Note

Title	Deadline 3 Noise Responses		
Project	Gatwick Airport DCO		
Reference	28AD.NT.4.0	Author(s)	BHo
Date	13 May 2024	Reviewer	VC

REP3-071 - Supporting Noise and Vibration Technical Notes to the Statements of Common Ground

Appendix 2: Slow Transition Fleet Noise Contours

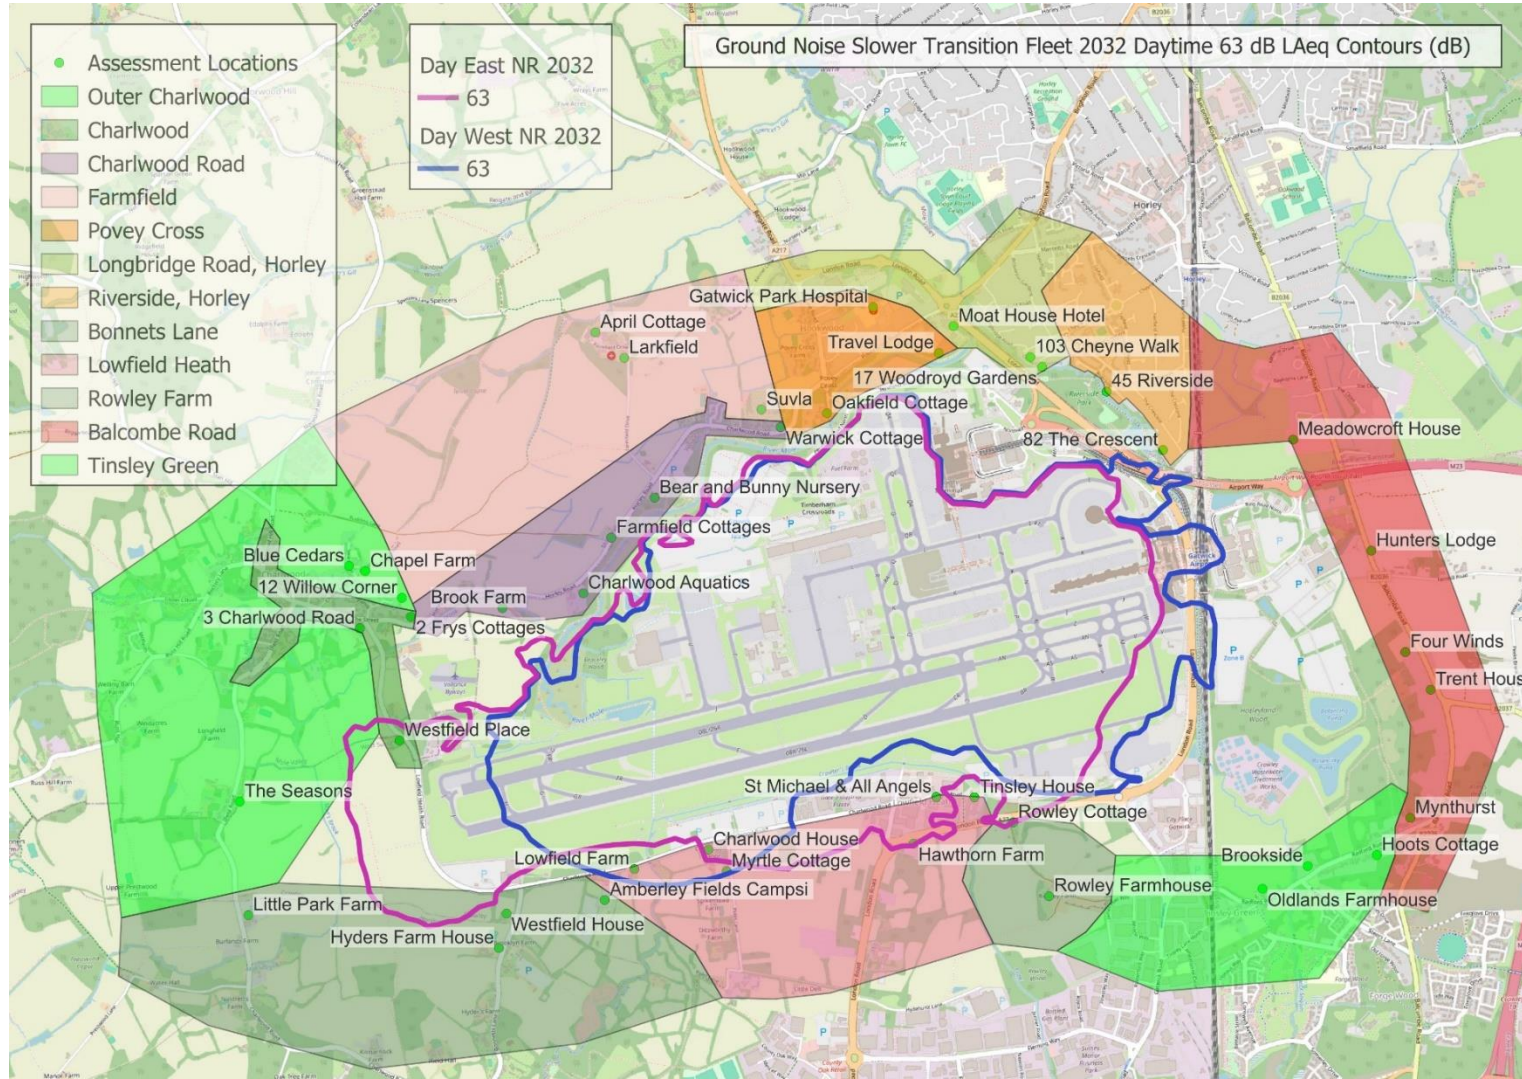
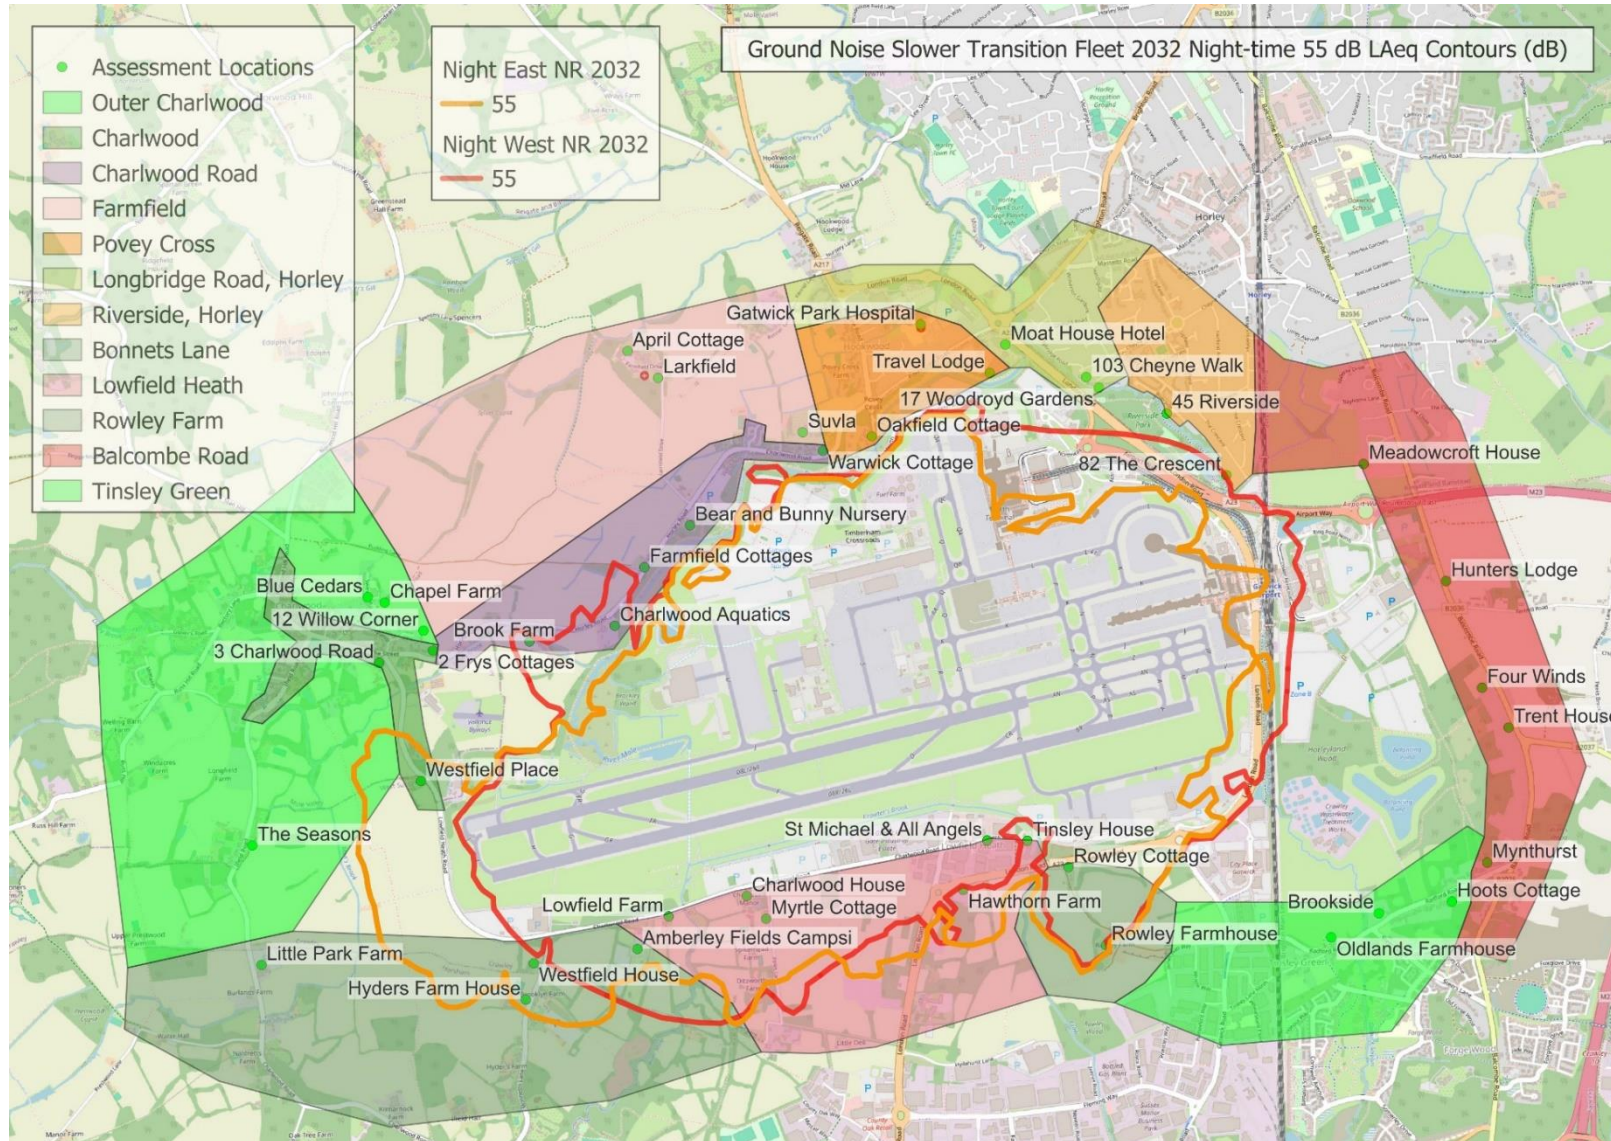
The Applicant provides in Appendix 1 of Appendix B the updated tables for the Central Case; in Appendix 2, the noise contours for the Slower Fleet Transition are provided. Given that the Applicant is now stating that their core case is the Slower Fleet Transition, comparable information to that contained within APP-173 and Appendix 1 of REP3-071 must be produced for the Slower Fleet Transition.

Appendix 2 The Applicant should provide the aggregate summers day ground noise contours between LOAEL and SOAEL for day and night-time on high quality OS mapping, using wind corrections as per ISO 9613. It would enable other parties a much greater insight into the full extent of ground noise impacts than is currently known.

2.5 The locations where EGR is to take place are shown on ES figure 5.2.1a but the text in 2.5.3 does not provide percentages for all locations. Regardless, these locations do not appear to correlate with the noise contours provided in Appendix 2 of Appendix B of this document. If EGR has only been assessed for L_{max} , then it is necessary to set assessment criteria LOAELs and SOAELs for this particular index.
